**KIRKLEES METROPOLITAN COUNCIL
INVESTMENT & REGENERATION SERVICE**

Reference No: 2021/62/90133/W

Site Address: 19, Meadow Park, Kirkheaton, Huddersfield, HD5 0HX

Description: Erection of single storey rear extension and porch to front

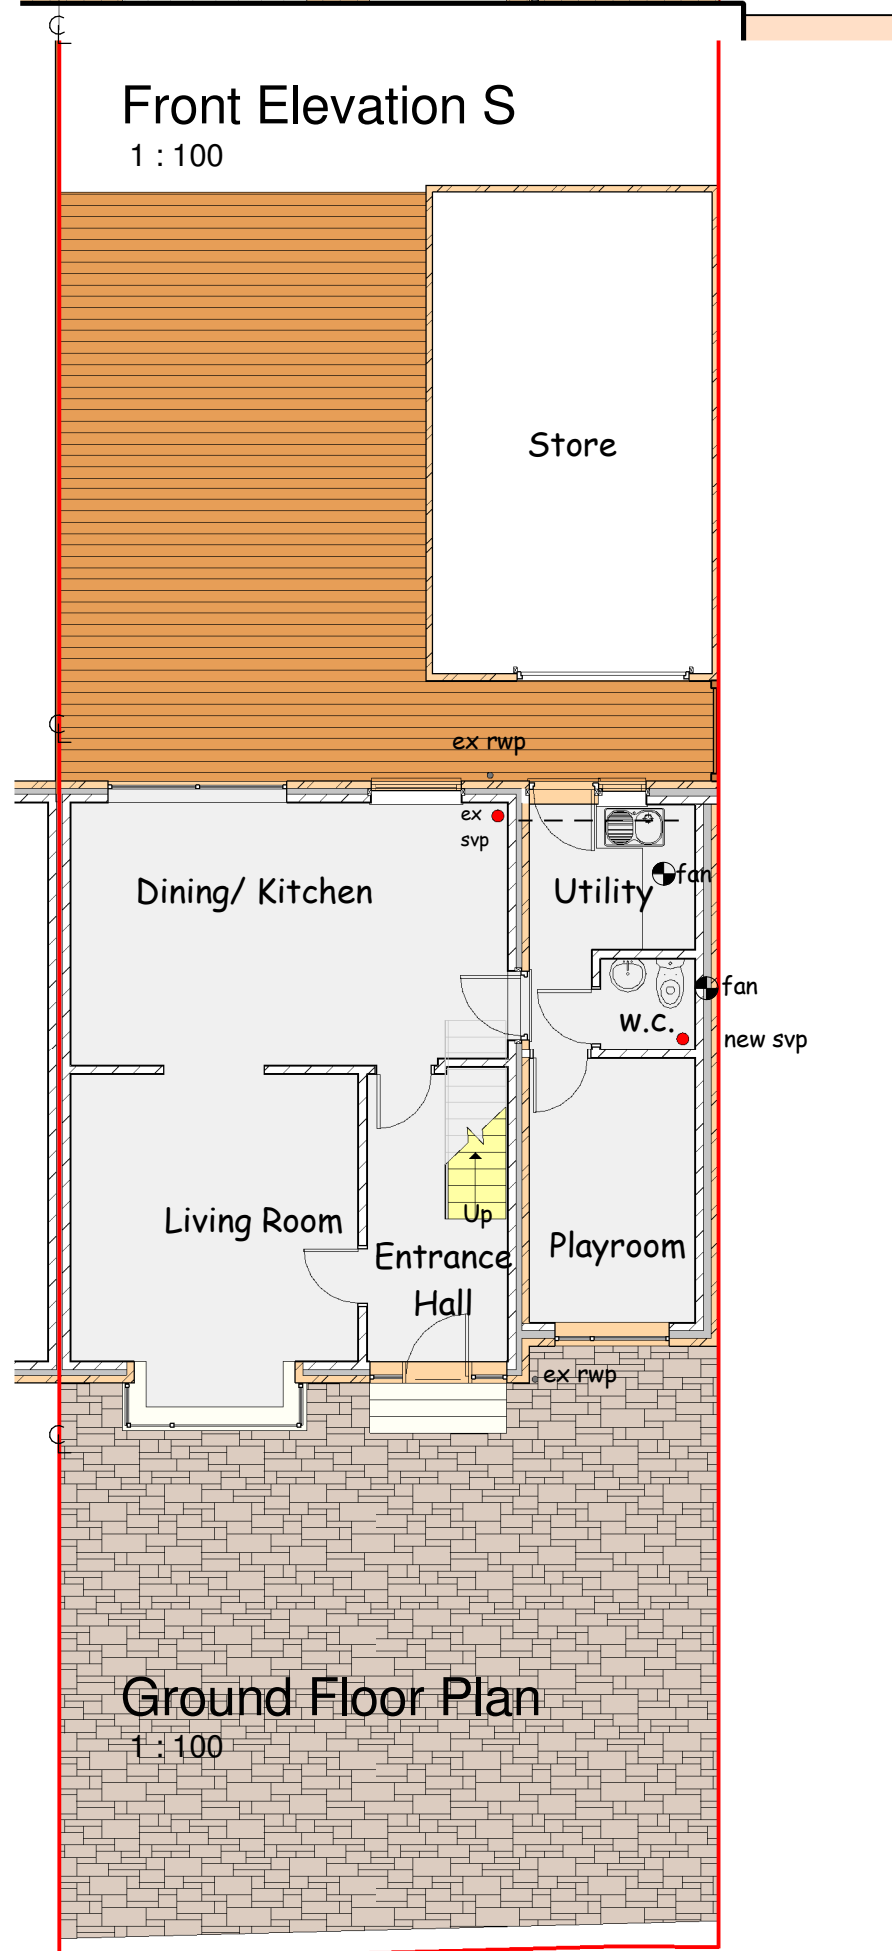
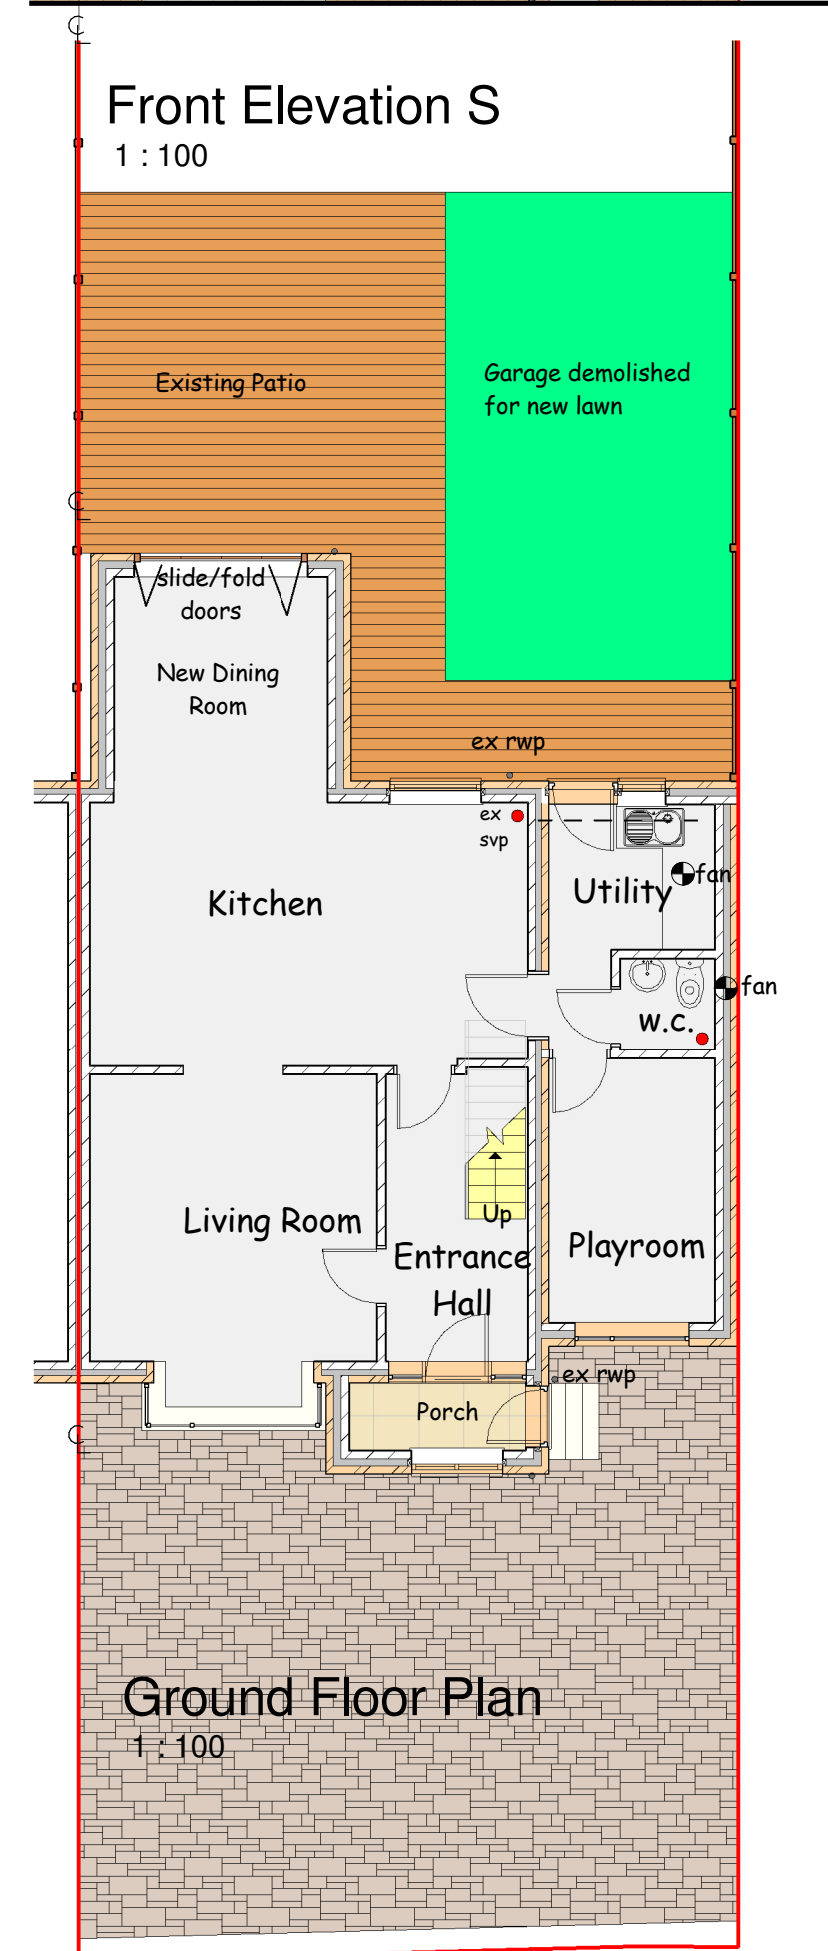
The case officer sought amendments regarding the proposed position of the rear extension. It was suggested that revised plans be submitted, setting the extension away from the neighbouring shared boundary slightly and enabling the existing fence to be retained between the neighbouring property. This amendment was sought with regard to the overall design of the extension and LP24 of the Kirklees Local Plan.

Revised plans were submitted, these showed the extension to be set away from the shared boundary by about 0.15 metres and the shared fence to be retained.
